19/01419/DISC

Cedar Lodge, North Side, Steeple Aston

Discharge of condition 4 (schedule of materials), 5 (cross section and colour / finish), 7 (French drain details) and 8 (stone floor method statement) of 19/00532/LB

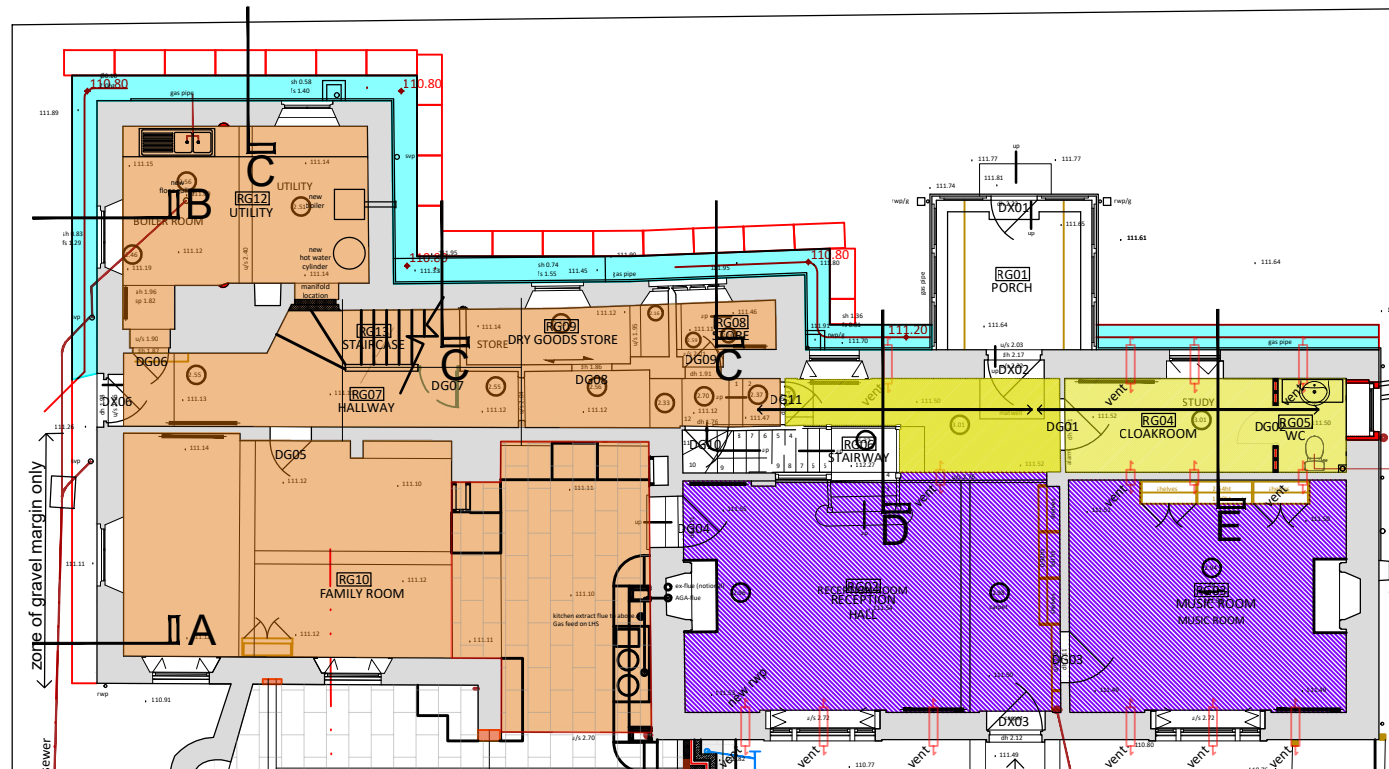
- The only 'opening' details appear to relate to the WC on the main house. This is shown as having 24mm double glazing which is unacceptable on the listed building and will not match the profiles of the existing windows (this was raised by email 7/6/2019). The glazing bars also not appear to be genuine and integral to the window frame.
- There are no objections to the window being painted white. It is assumed that the window will be constructed of timber not just finished in timber.
- The additional information submitted implies that that information already submitted is sufficient to discharge the condition.

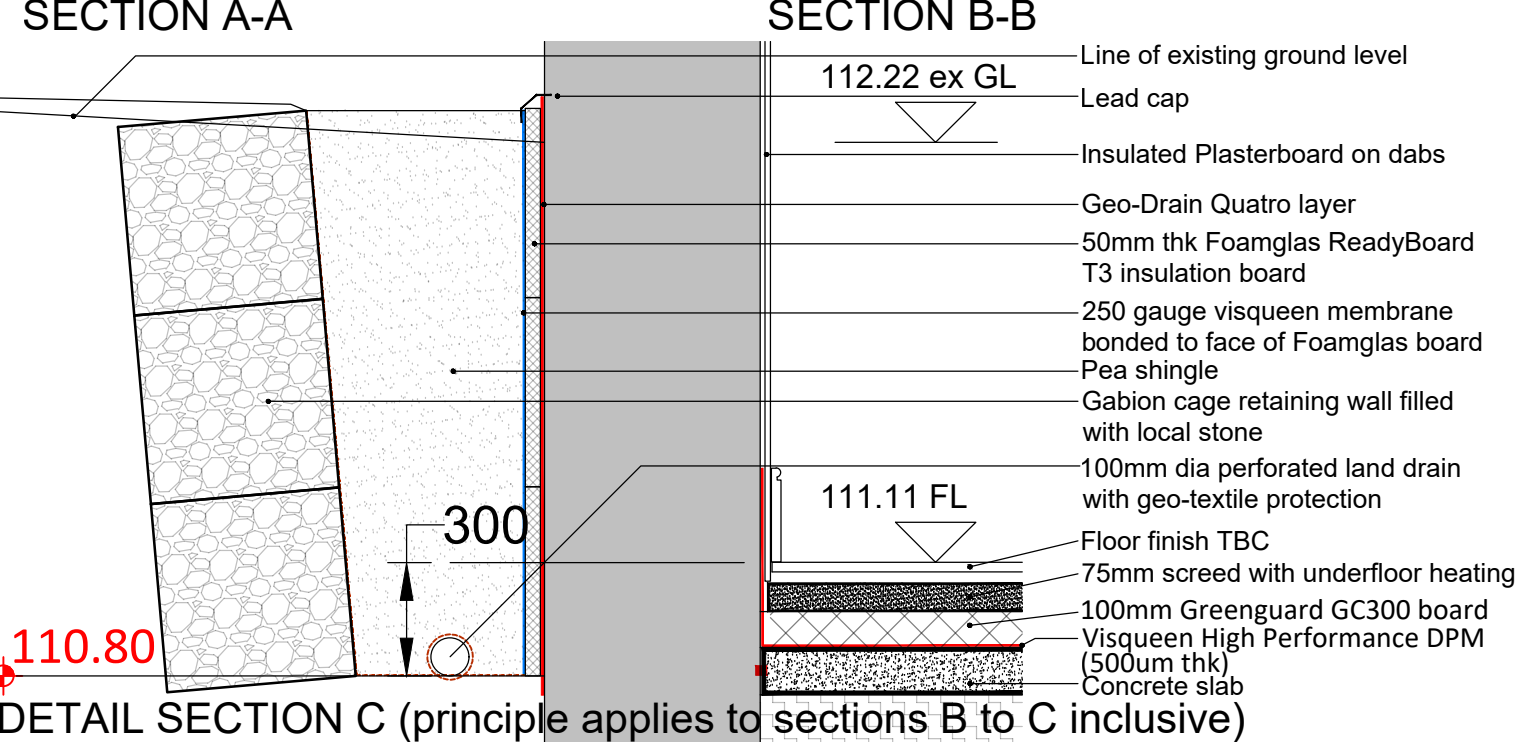
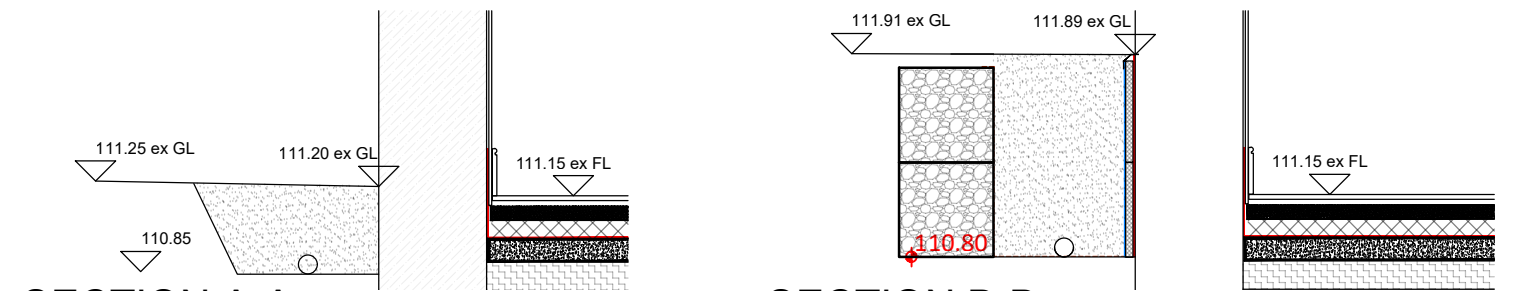
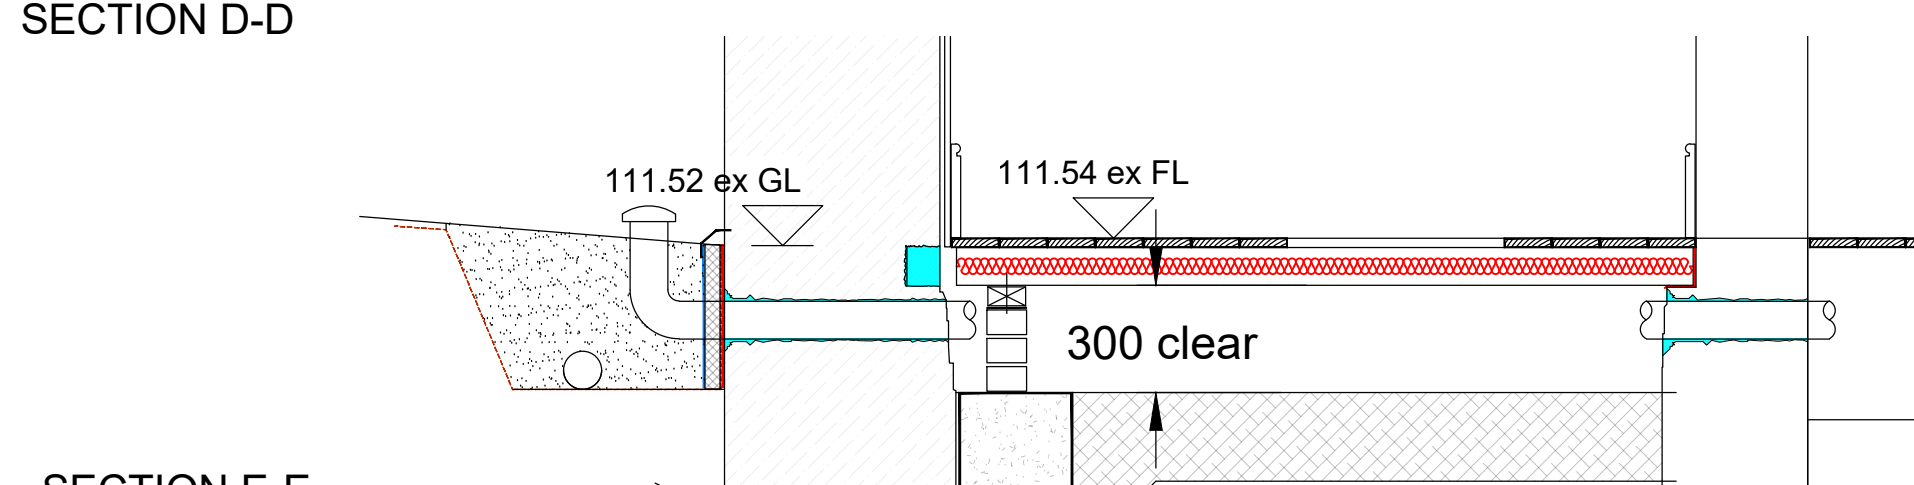
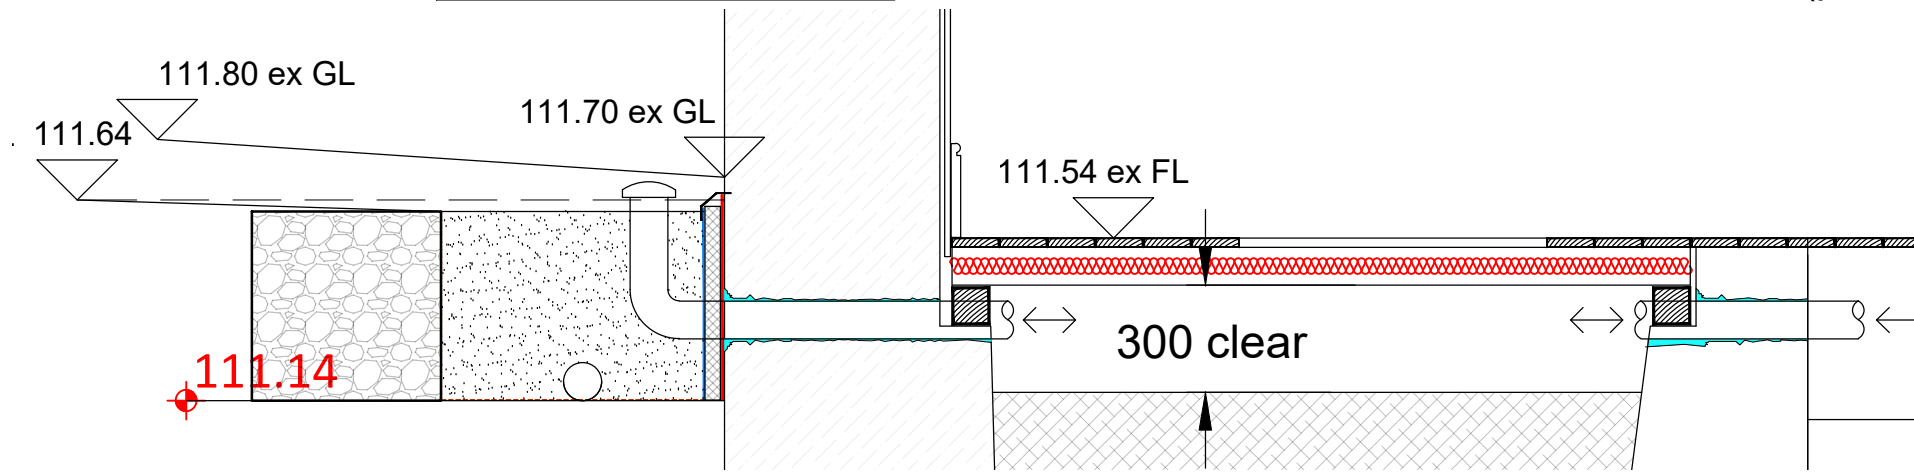
- It is appreciated that full drawn details have been provided of the French drain, but it would be useful for an accompanying written explanation / justification / method statement. In particular justifying the use of the various products (including insulation board on the exterior) and how this will impact on the historic fabric.
- **Sufficient justification has now been provided and this can be discharged.**

Project	Cedar Lodge, North Side Steeple Aston OX25 3SE
Title	Ground Floor Demolitions
first issue	06.06.2019
checked	djs
scale	1:50 @ A3
drawn	TW
dep. no.	
2018-1014-DM01

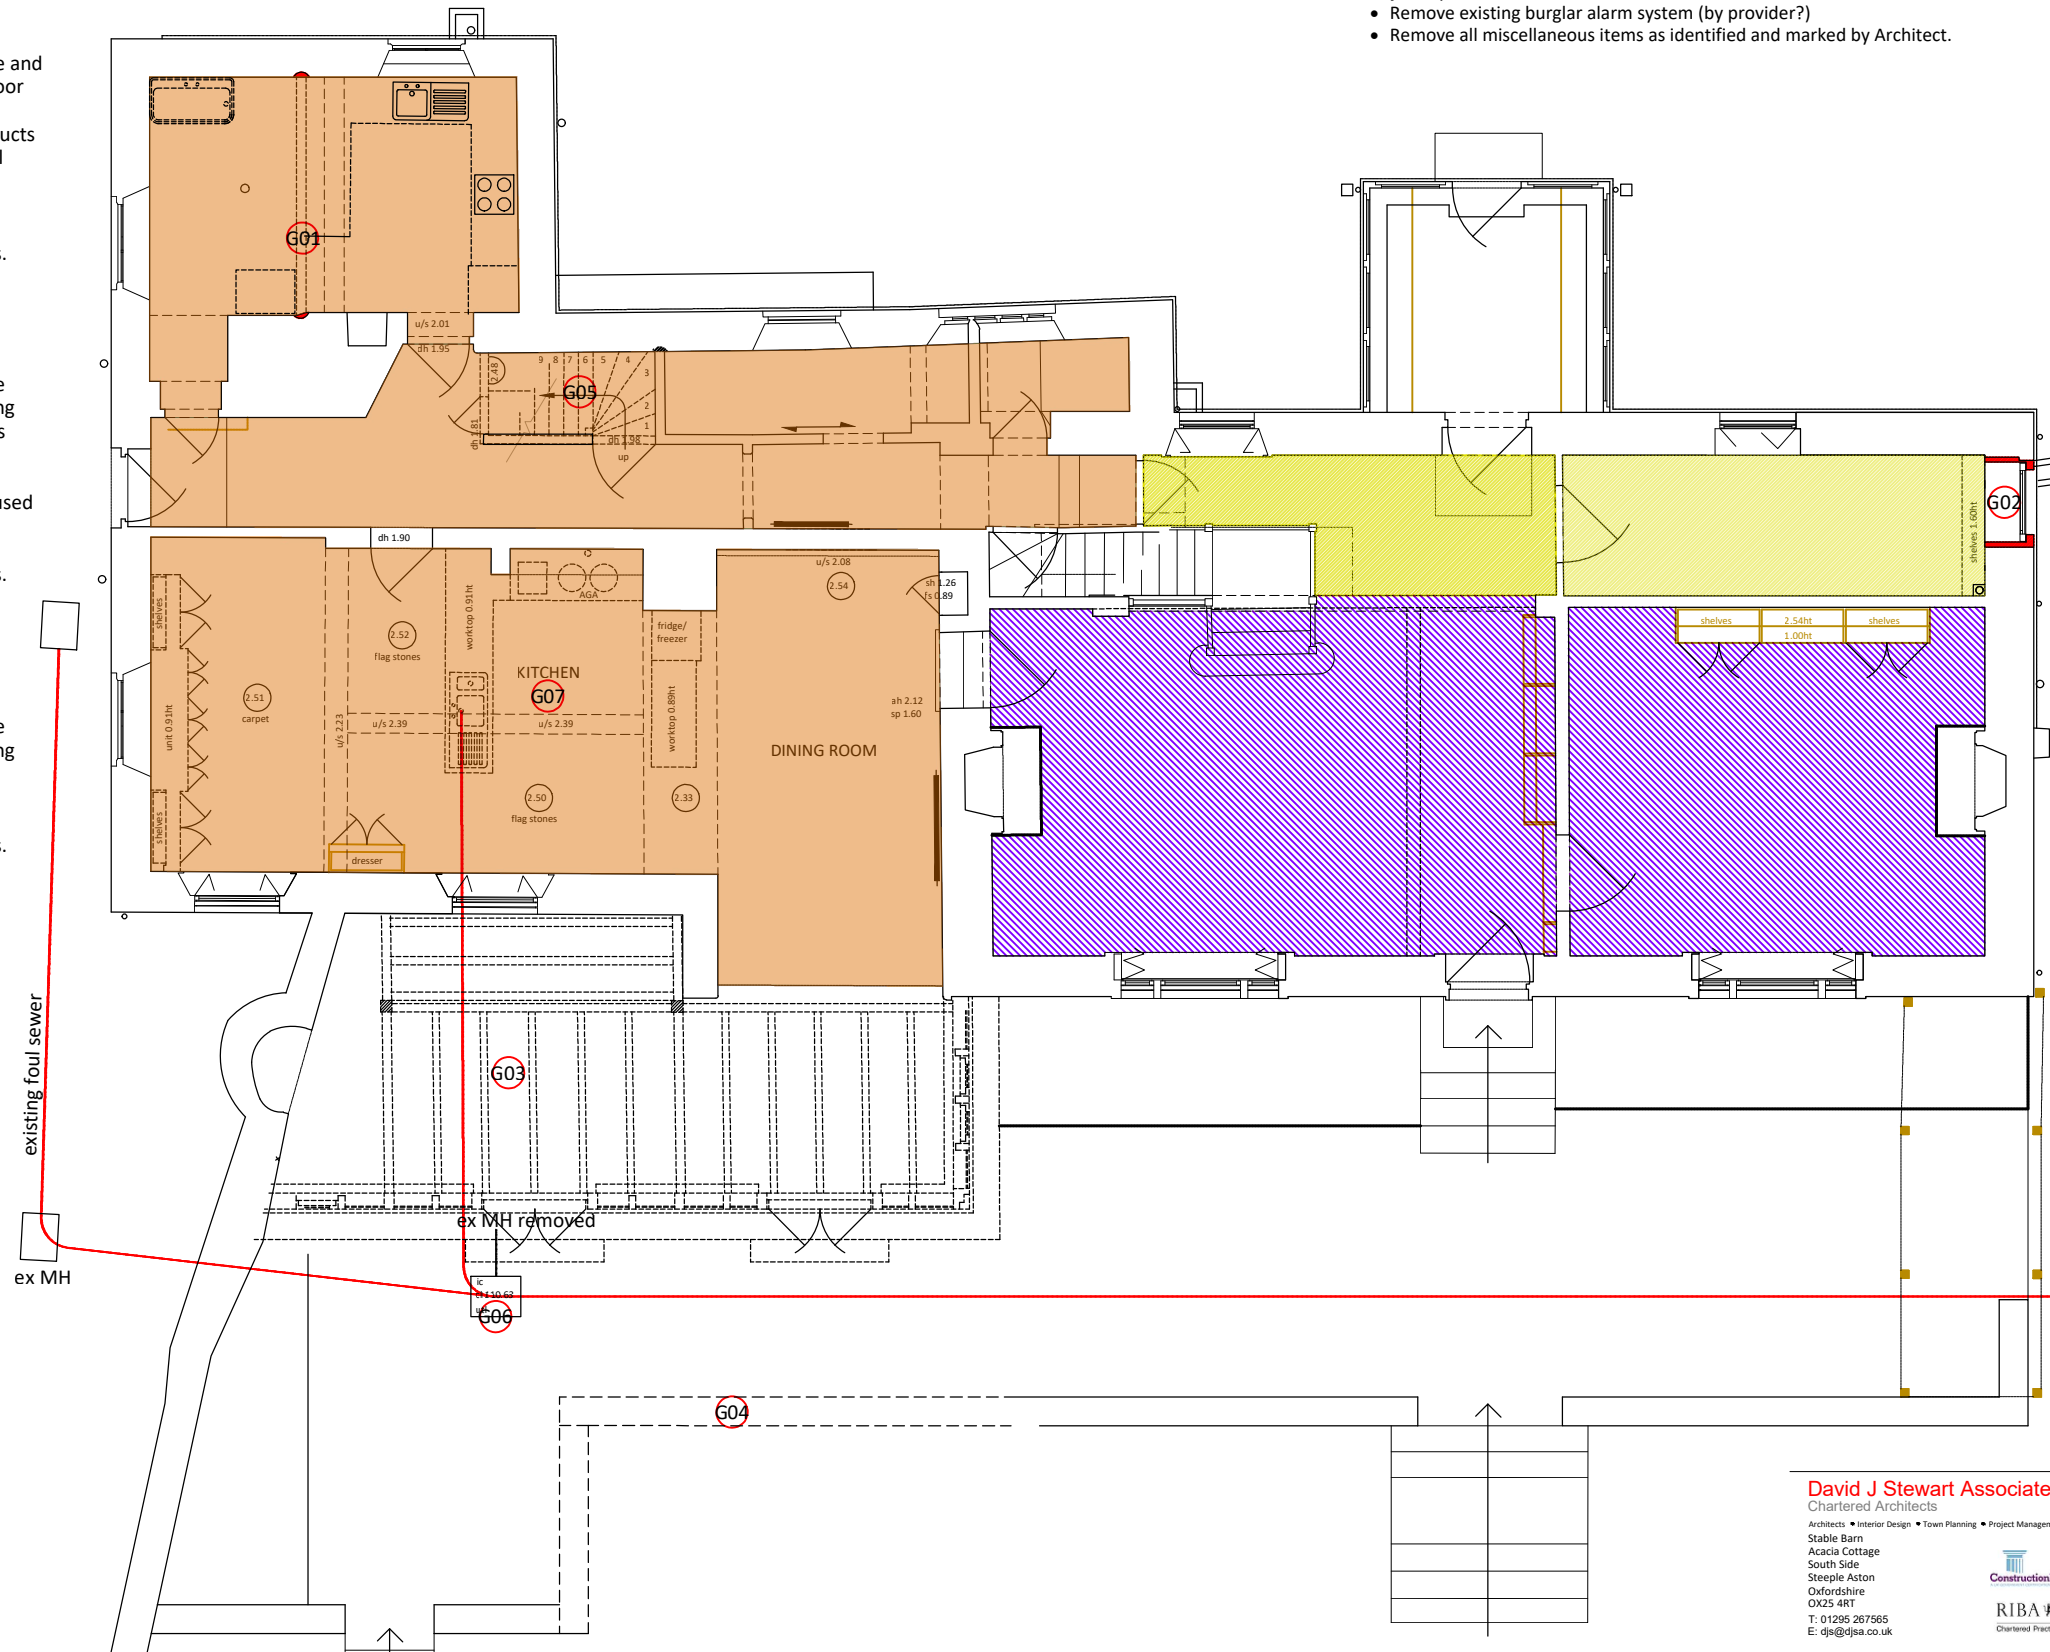
- Information has been submitted in relation to the works to stone floor in the family room (which was included within the application), but it is also clear from the plans that there are proposed works to other areas of flooring which weren't mentioned during the application. It is unclear whether the information submitted as part of this discharge of conditions can be used to effectively grant consent for these items.

- I have been on site and seen the issue with some areas of the floor (where the timber floor boards and wall plate are sitting directly on the ground in some areas) and agree that a solution needs to be found. If this format can be used to effectively give consent for these works the information about why the work needs to be undertaken should be set out in written format so there is a formal record.

- The information is provided in drawn format, but there is no back up information about why particular products (mentioned in the condition) have been used and the impact these will have on the historic fabric. A written method statement to accompany the drawings would assist with this.

- **The additional information provides a sufficient justification for the works.**
- **A decision needs to be made about whether the works to floor throughout the ground floor can be considered as part of this discharge of conditions application.**
